**KIRKLEES METROPOLITAN COUNCIL
INVESTMENT & REGENERATION SERVICE**

DELEGATED DECISION TO DETERMINE PLANNING APPLICATIONS

Reference No: 2018/62/91312/E

Description: Erection of detached storage/garage

**west front elevation**  
1 : 50

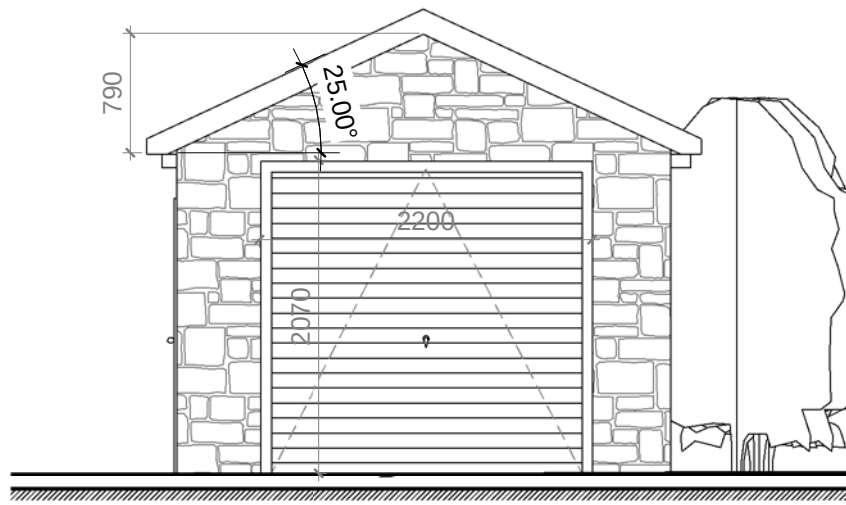
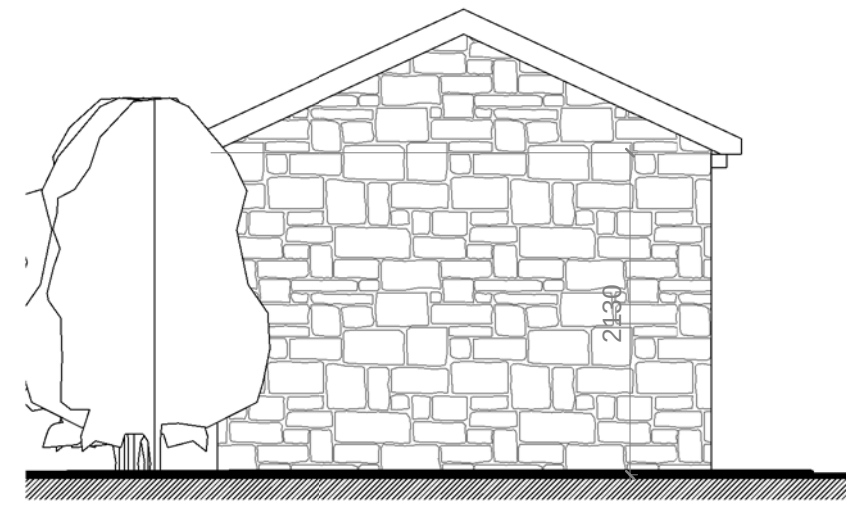
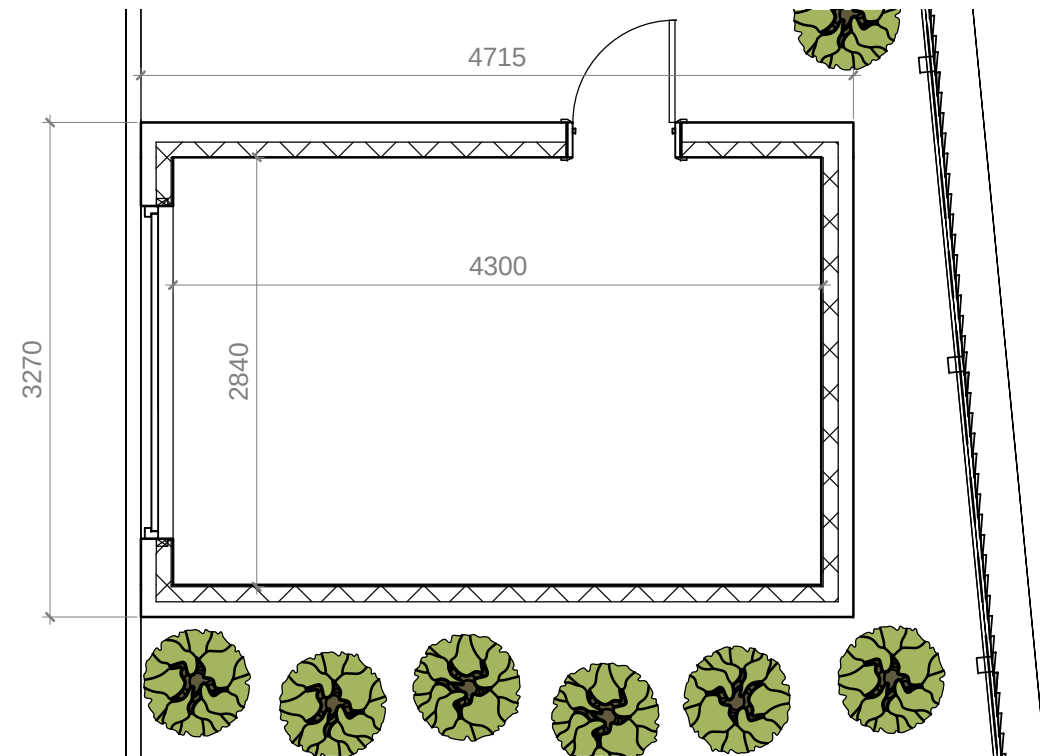
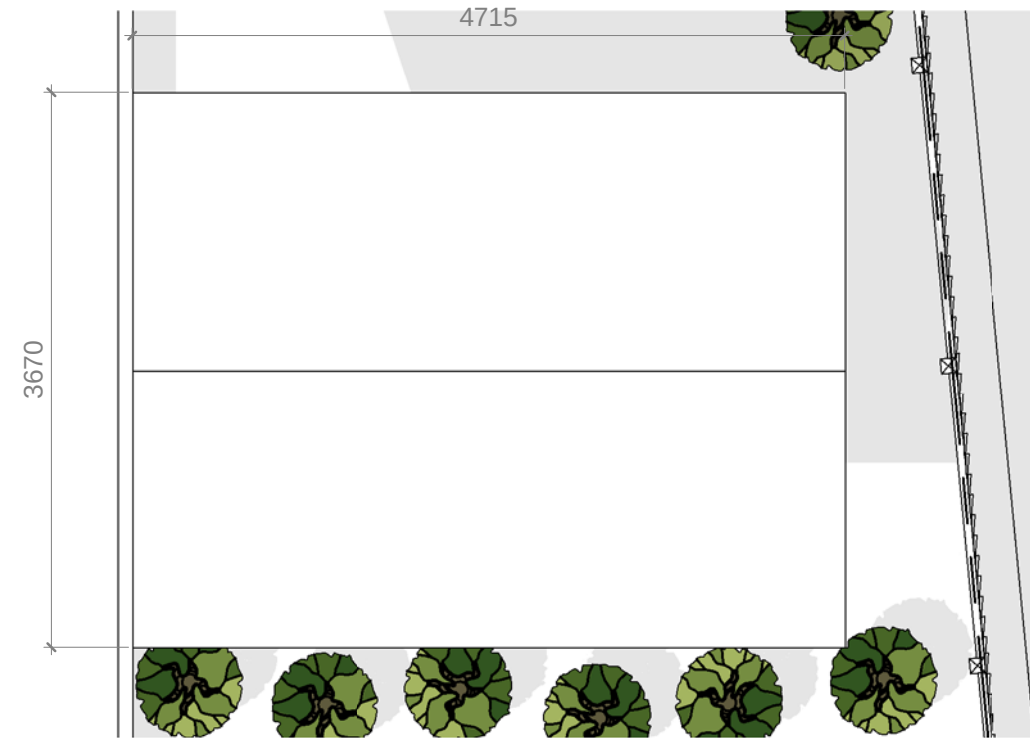
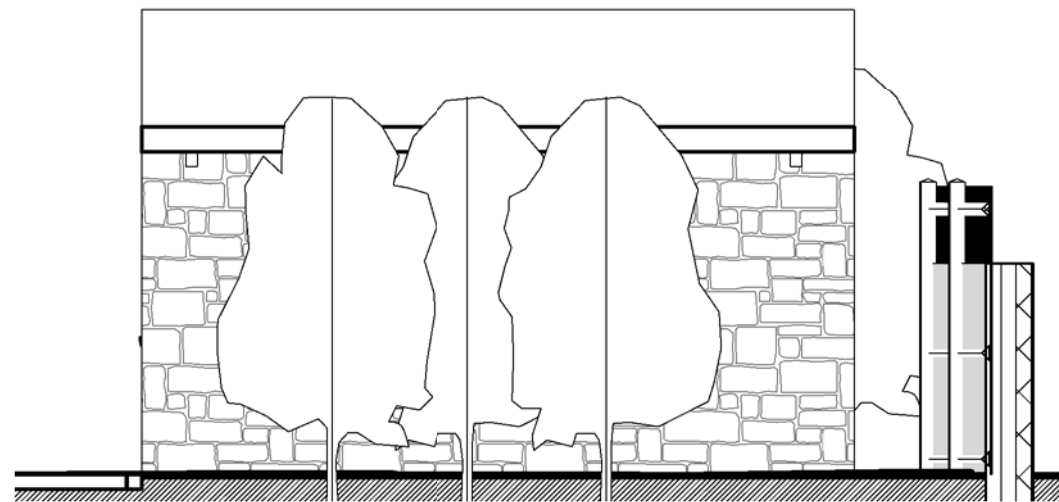
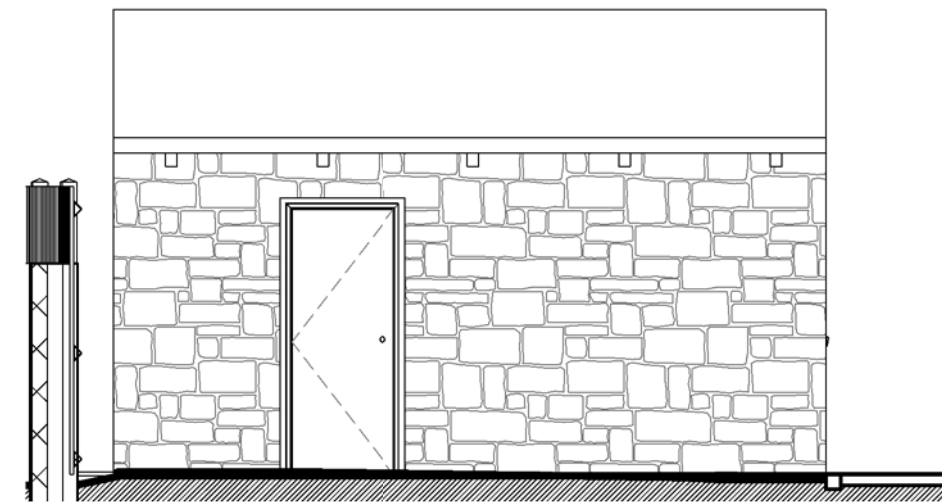
- Plans do not reflect the size of the garage.
- No requirement of occupiers of plot 4 for mobility scooter storage.
- Building makes the adjacent dwelling feel claustrophobic.
- Garage should have a flat roof.
- The garage has already been built.
- Garage not in keeping.
- Blocking of light and views.
- Planting will not disguise the garage.
- Planning officer should have stopped the building of the garage.
- Building without permission should be censured and the garage removed.

In terms of the design detail, the building has a twin pitched roof to match that of the host dwelling and is constructed of the same materials. A shallow pitch roof was first proposed however given the location to the front of the dwelling a pitched roof to match that of the host property is considered more appropriate.

- Building makes the adjacent dwelling feel claustrophobic. **Response:** residential amenity has been assessed in the report above.
- Garage should have a flat roof. **Response:** The impact the development would have upon visual amenity has been assessed above. It is considered that the use of a pitched roof, which would match that incorporated on the wider development, is more appropriate in this context than a flat roof design.
